3d Community Church

659 Graham Rd Sanford, NC

9/3/25

Building Inspector
Harnett County

LIFE SAFETY PLAN

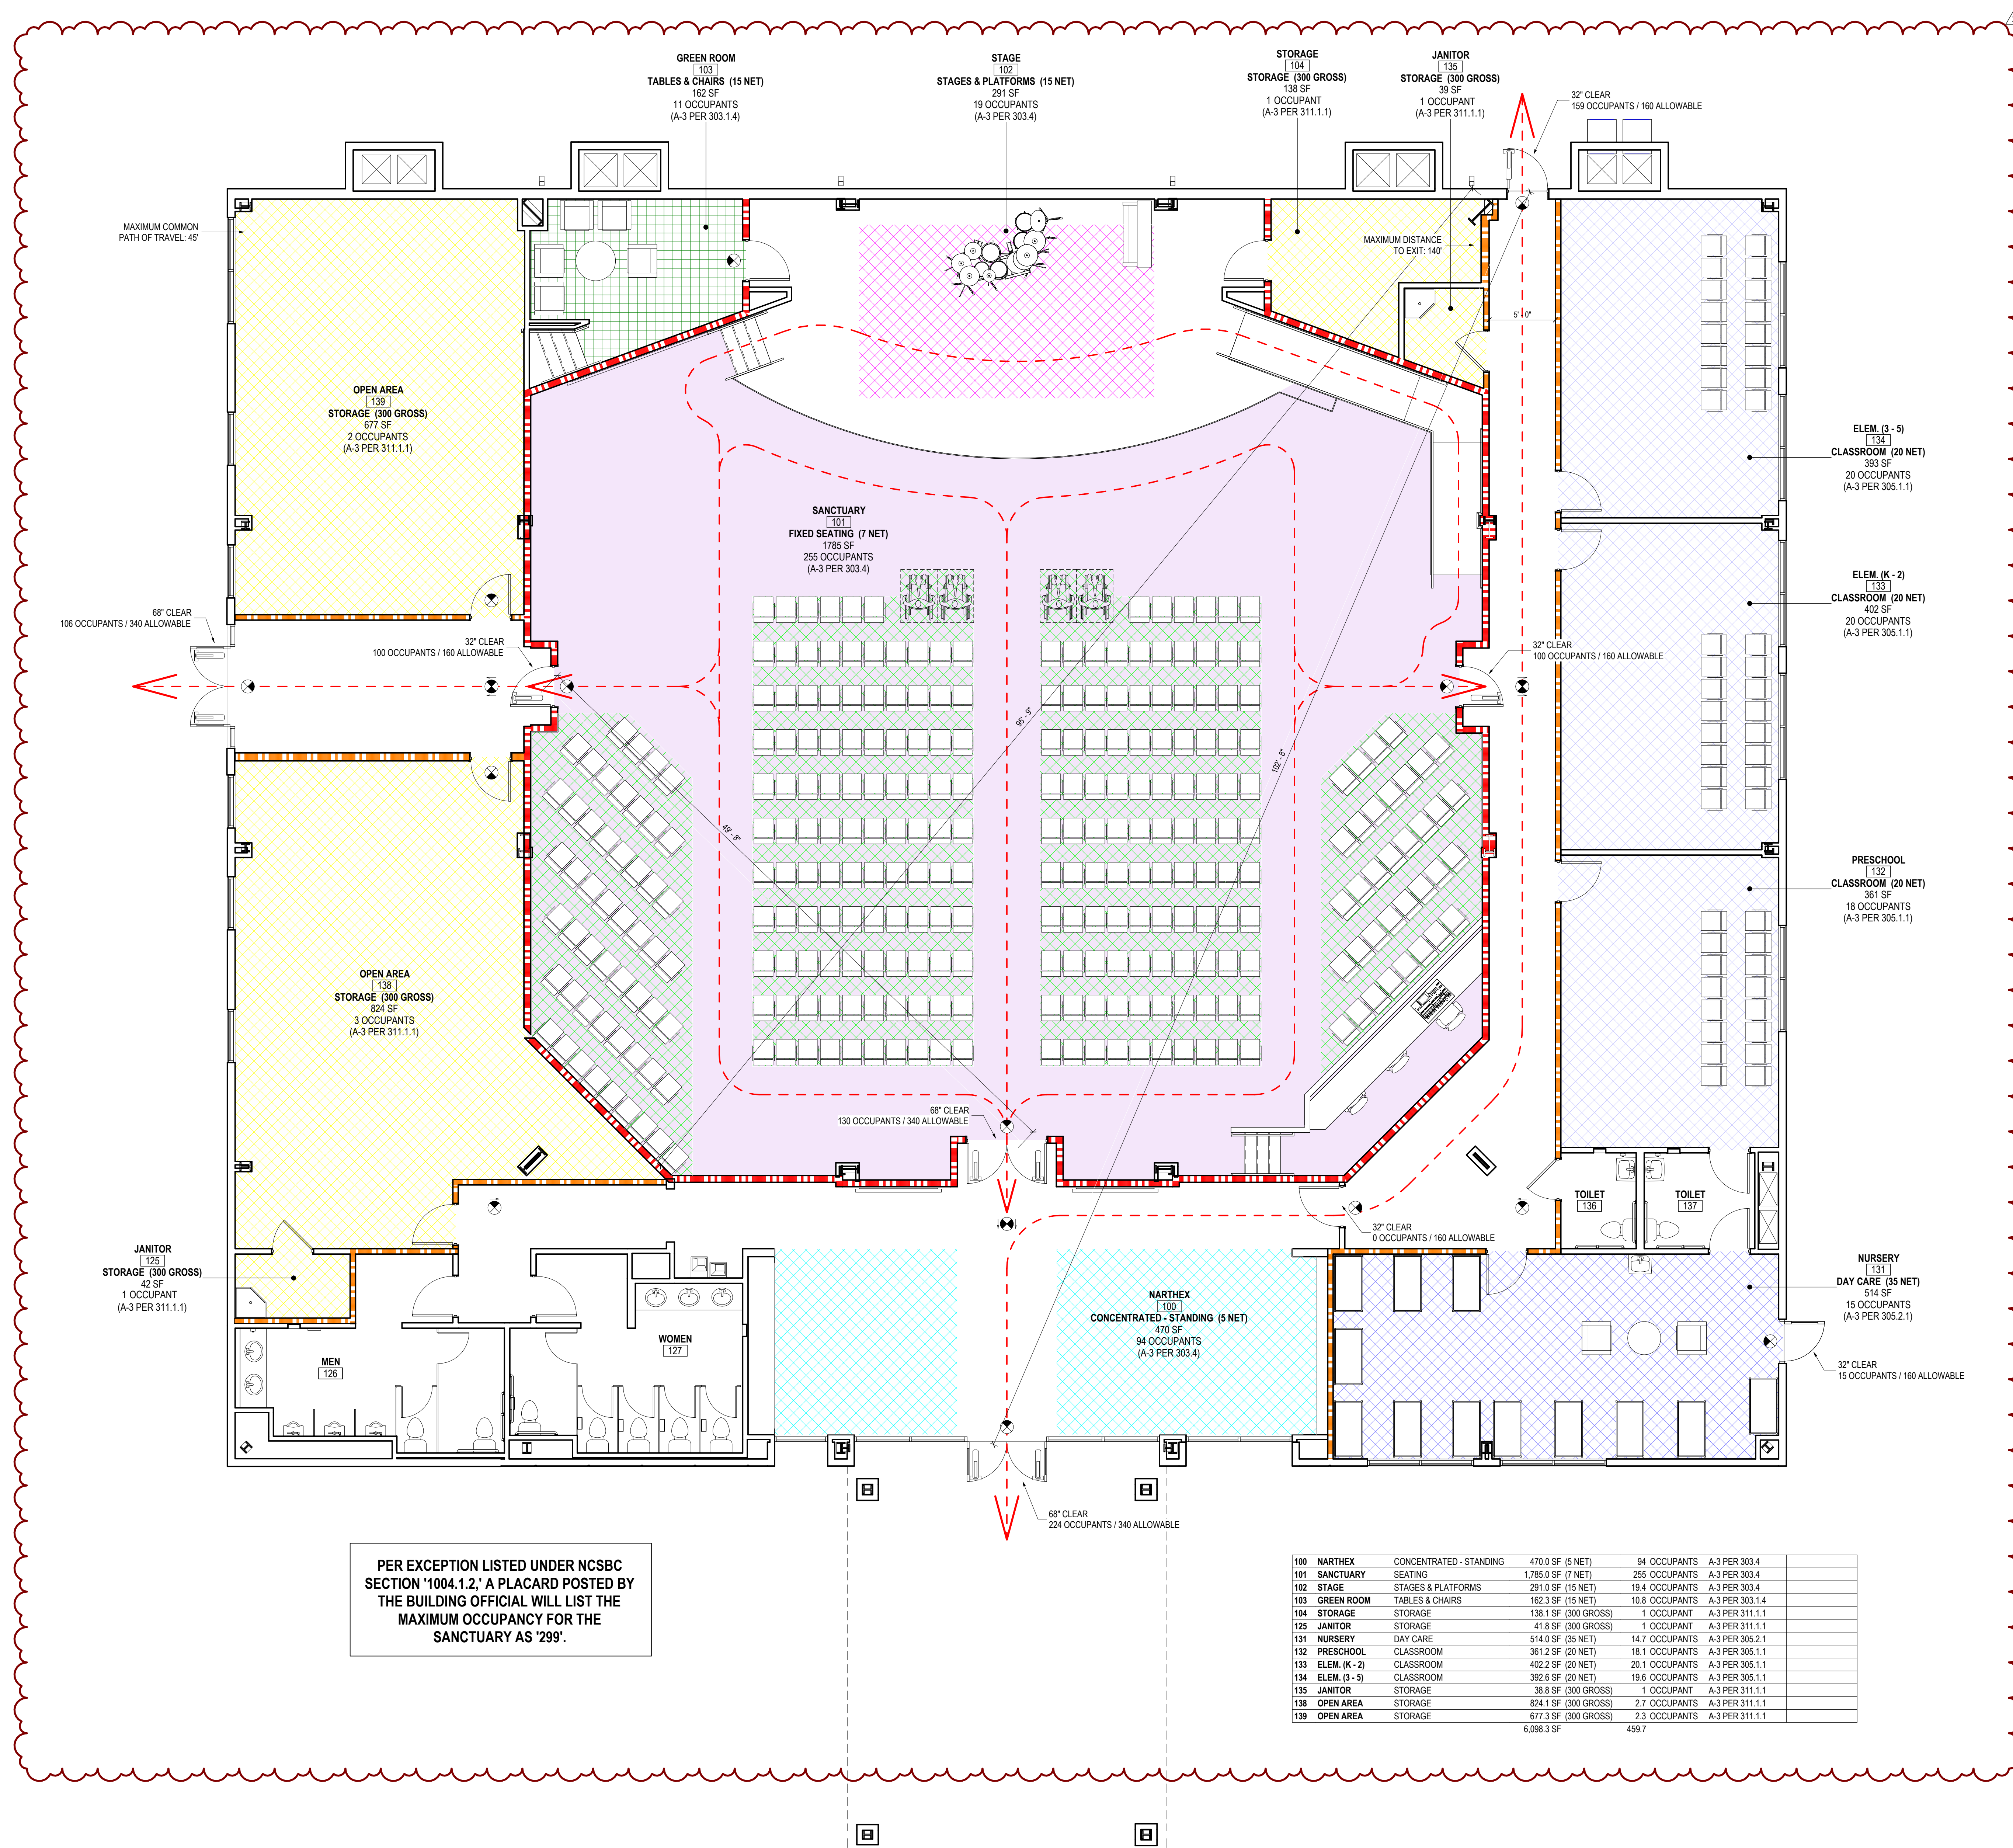
General contractor shall extend the one and two-hour fire rated wall framing and sheetrock tight to the roof insulation/tarp system. Apply fire caulk at the top of sheetrock. Allow deflection at the roof structure. — Follow UL Designs UL419 and V449. Provide top of wall condition at rated walls indicated in red and orange below.
